Qdoba  
7650 SE 27<sup>th</sup> St Suite 106  
Mercer Island, WA 98040  
Permit: DSR24-008

Corrections Response.

N01

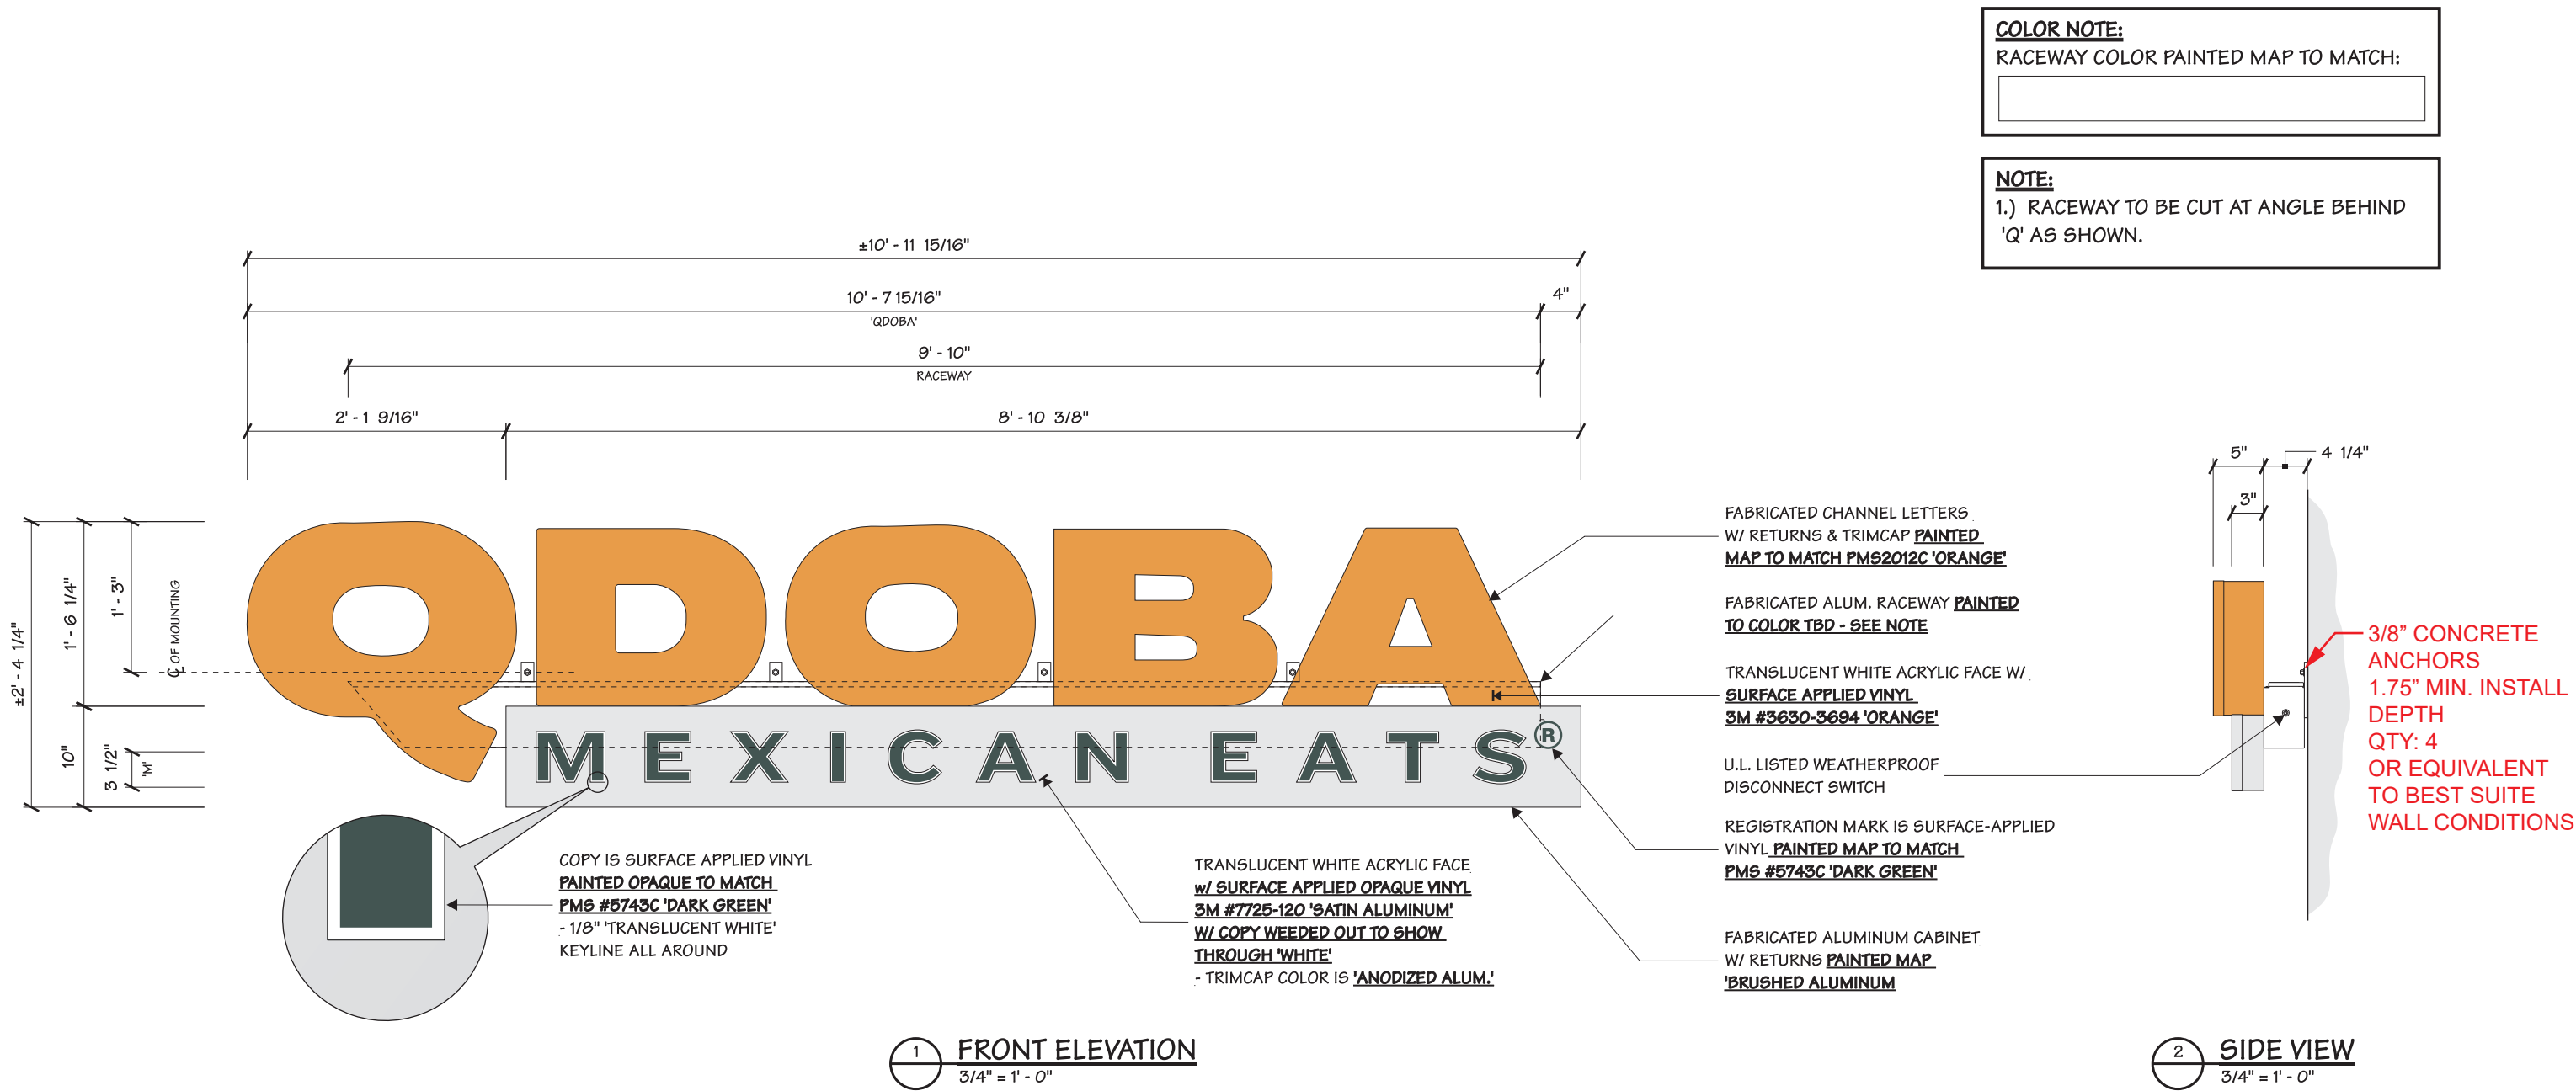
Correction Request: Please specify attachment method on plans. I.e. threaded rods/through bolts/Specify size and depth of attachment, spacing, and quantity

Response: Plans have been updated with hardware specs.
